From: Erin Moore
Sent: Thursday, August 22, 2013 1:46 PM
To: Jeff Watson
Subject: FW: BL-13-00008 Orr
Attachments: Orr.pdf

BL-13-00008 Orr

Drawing file: BL-13-00008 Orr / BL-13-00008 Orr Old Site Plan Septic and Well.pdf

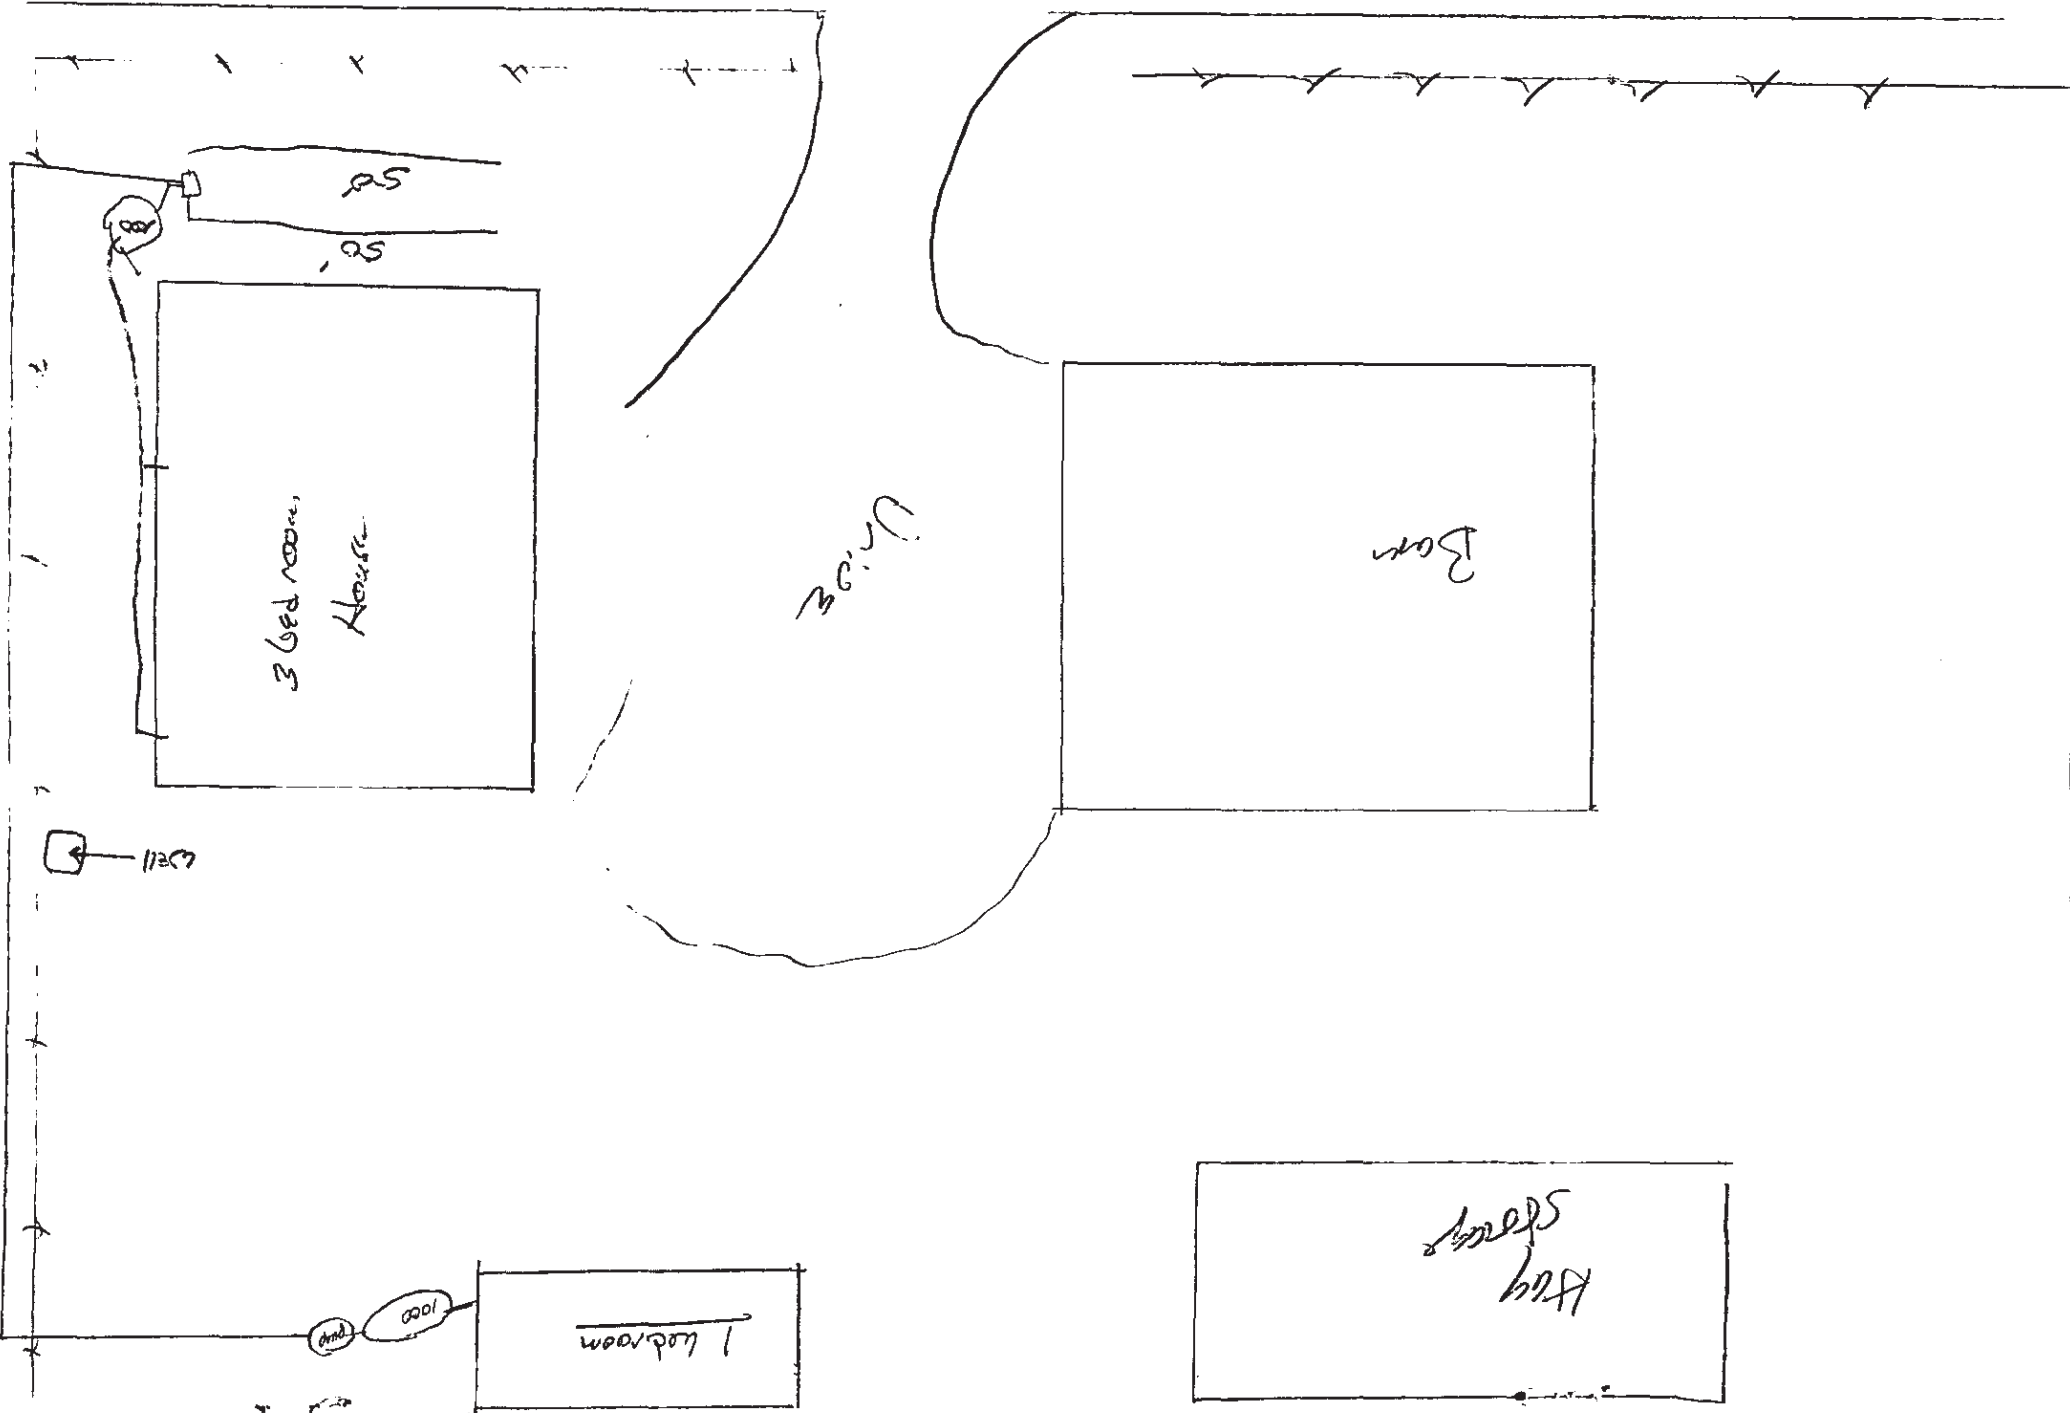
Chuck or Chris: Can we get a well location and distance to proposed new property line for this one? I've attached a site plan from (I'm guessing) an old septic permit but it is tough to tell for scaling and location and I don't have a precise location for the new line.

We need to get a measurement on the distance the existing well is from the proposed west property line on this one.

Holly the well also appears to be within the proposed boundaries but not sure of the distance from the property line, may inquire for further information or do a drive by. Thanks.

Public Health does not have any issues with this one now that we know how far property line is from well. Thanks.

Sorry for the delay in getting this back into you. Attached is an image with the 5 acre parcel to scale and the location of the well and drain field. The well will be located a little over 100' from the proposed boundary. Please review and contact me back with changes.
